Submission Form

Epping to Thornleigh Third Track Proposal. Application number SSI 5132.

Figure S.6 Cross-section and elevation - New Cheltenham Station concourse building (see also S.5 for artist's impression)

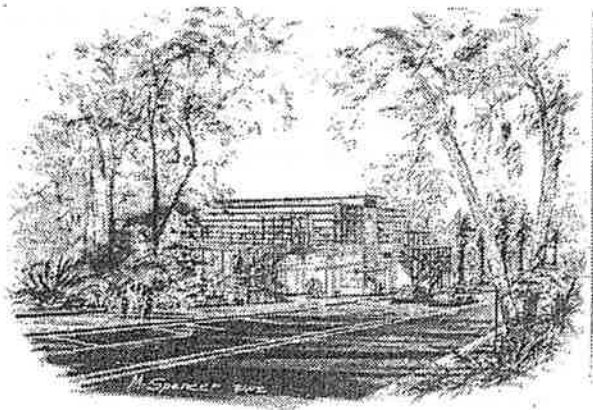
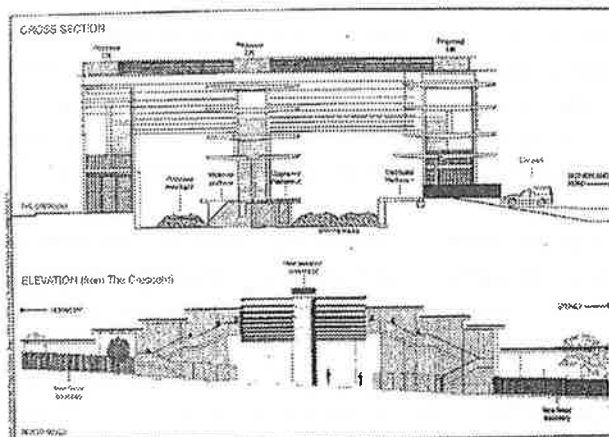
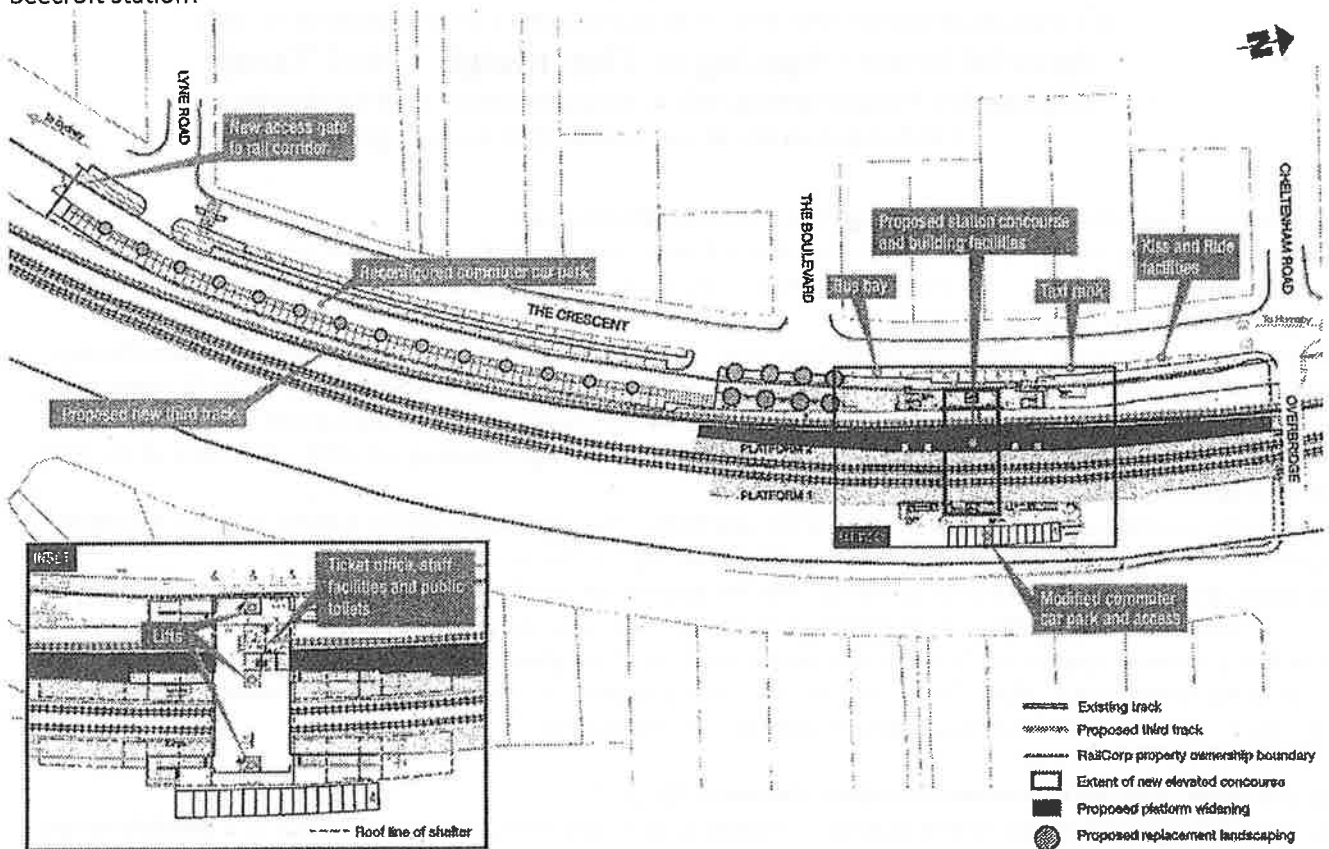
- The proposed redevelopment of Cheltenham Station shows no regard for the HCA. The visual impact of the proposed 13m high glass and steel concourse is totally unacceptable in this HCA.
